**WELWYN HATFIELD BOROUGH COUNCIL
EXECUTIVE DIRECTOR - PLANNING, PUBLIC PROTECTION AND GOVERNANCE**

DELEGATED APPLICATION

Application No: 6/2019/1688/HOUSE
Location: 69 Lavender Close Hatfield AL10 9FW
Proposal: Erection of a two storey side extension
Officer: Ms Lucy Hale

Drawing Title Proposed Extension	
Drg No. 2626 - 2	Rev

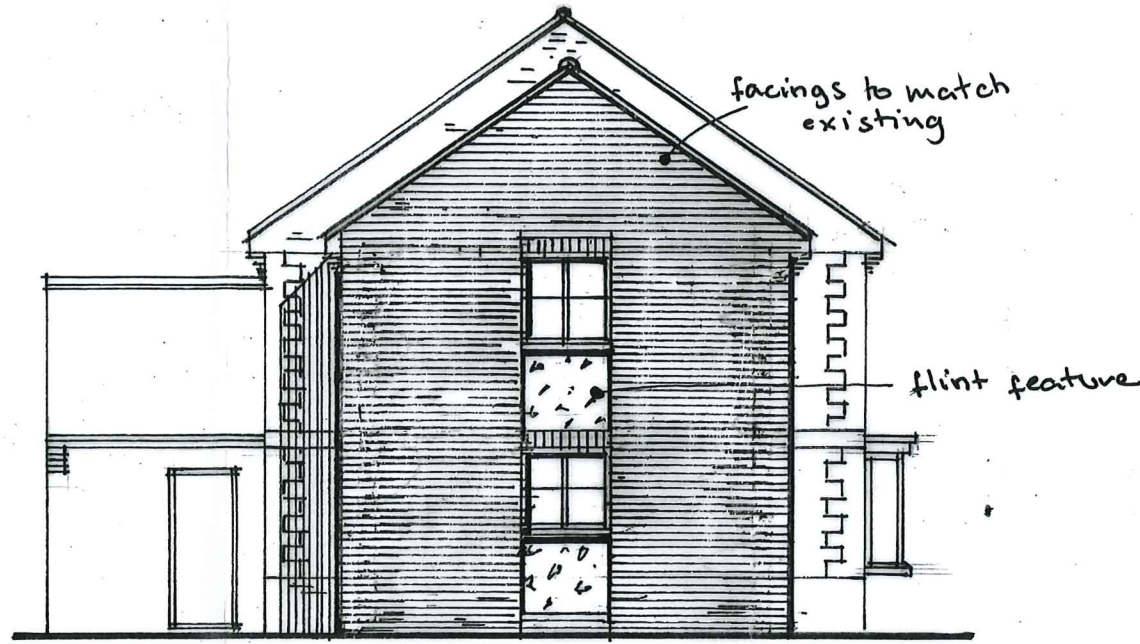
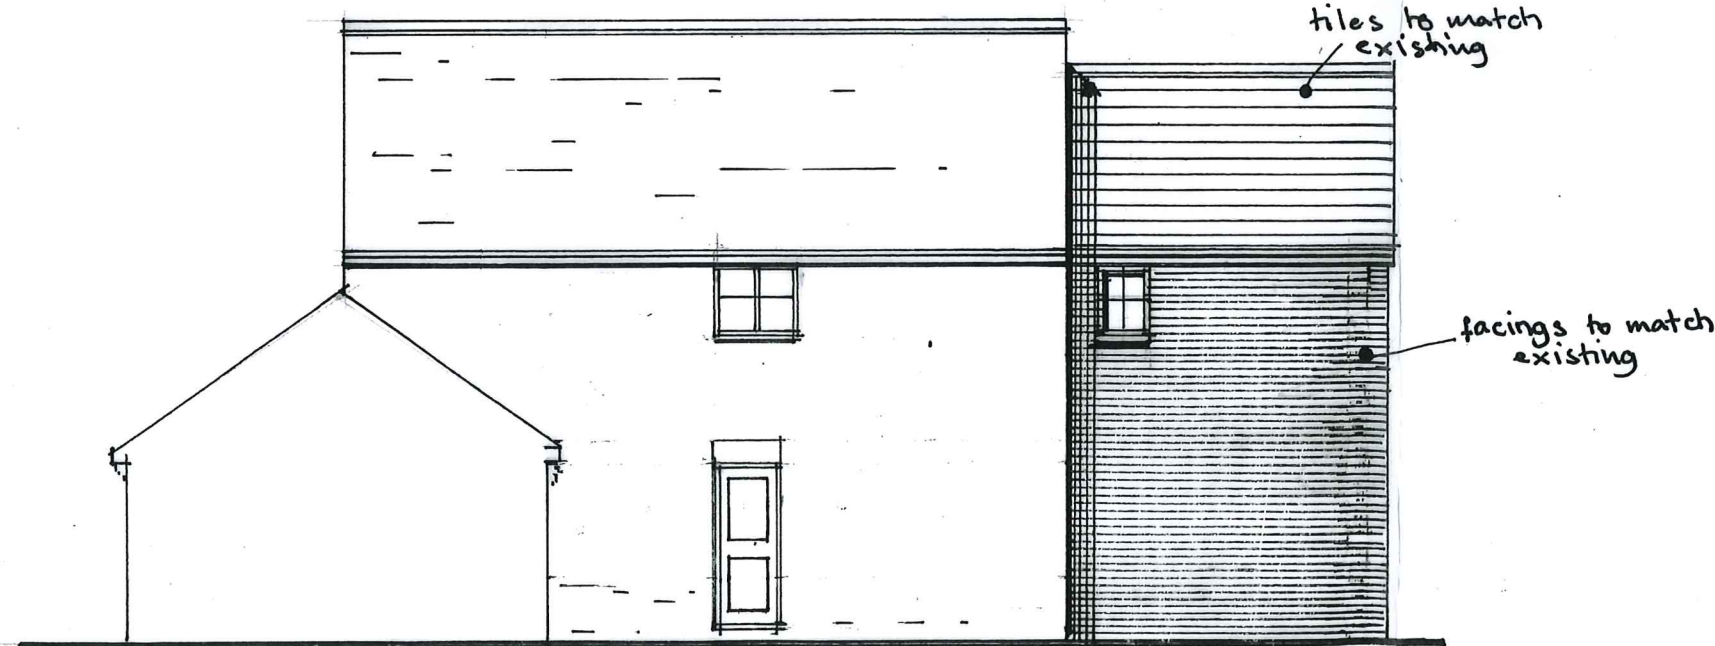
The proposed two storey side extension would be set down from the ridge height and set in from either flank elevation of the existing dwelling and its depth is considered to be in proportion to its overall projection. As a result, the extension is considered to appear subordinate in scale and would not overwhelm the existing dwelling. Furthermore, it would feature a gable end with facing brickwork and flint detailing which would complement and reflect the character and appearance of the existing dwelling.

The extension would project closer to the south boundary of the site and Ivy Walk footpath, however would maintain approximately 1.9 metres, which would comply with the Council SDG which requires 1 metre distance at first floor. The resultant building line and built form in comparison to Ivy Walk would be similar to No. 30 Lavender Close which is opposite the site to the east. It is not considered that the siting of the extension would appear contrived or unduly prominent within the existing pattern and layout of properties within the immediate area.

The neighbouring property is No.11 Ivy Walk which comprises a detached property. No comments have been received from this occupier. The extension would project off the south side elevation of the property, past the front elevation of No.11 and it would be set in from each flank elevation. A 45 degree angle has been shown from the windows on the front elevation of No.11 and outlines that the

extension would not cross this line. Given the orientation of the properties it is acknowledged that there may be an element of overshadowing to their habitable windows as the sun rises, however, throughout the middle of the day and afternoon, the extension would not restrict direct sun light entering these windows and therefore it is not considered that there would be a detrimental impact on their living conditions as a result. A window is proposed on the west side elevation at first floor which is indicated to serve a bathroom. This window would be conditioned as obscure glazed and non-opening above 1.8 metres to preserve the living conditions of the occupiers of No.11.

No.35 Cornflower Way is located opposite the site to the south. This property benefits from windows on its north elevation and therefore, the projection of the extension towards No.35 would result in a reduction in separation distance. A window is proposed to serve the new bedroom and given the reduced distance and new relationship, it is considered reasonable to condition the secondary bedroom window as obscure glazed and non-opening above 1.7 metres. In terms of light and overbearing impact, the proposed extension is considered to be of sufficient distance not to result in a detrimental loss of light to habitable windows or amenity space. Furthermore, given the siting of the extension and the orientation of the dwellings, the south siting of No.35 is not considered to be impacted in terms of light. In terms of overbearing impact and outlook, whilst the extension would project closer to No.35, it is not considered to be of distance or scale to result in harm to the living conditions of this occupier.

No. 30 Lavender Close is located to the east of the site. A first floor window is proposed to serve the new bedroom of the extension. It is not considered that this additional window would give rise to a greater level of overlooking than the existing relationship of these properties both of which benefit from bedrooms facing on to Lavender Close. In addition, the extension would be set back from the existing front elevation by approximately 1 metre which is a larger separation distance than the existing relationship. Whilst concerns have been raised in regard to loss of light and it is noted that the orientation of the properties may result in an element of overshadowing towards No.30, it is not considered that there would be a detrimental loss of light to the habitable rooms of this property which would result in harm to the occupiers living conditions. Whilst it is appreciated that the extension may result in a change of view than the existing, the extension would not be visually overbearing. This loss of a view is not in itself a material planning consideration and is therefore afforded limited weight in the consideration of this application.

1. The brickwork, roof tile, bond, mortar, flint feature panels, windows, detailing, guttering, soffits and other external decorations on the approved extension must match the existing dwelling in relation to colour, texture and detailing.

2. The proposed first floor windows located on the west and south elevation of the extension hereby approved must be obscure-glazed and non-opening unless the parts of the window which can be opened are more than 1.7 metres above the floor of the room in which the window is installed, and shall be retained in that form thereafter.
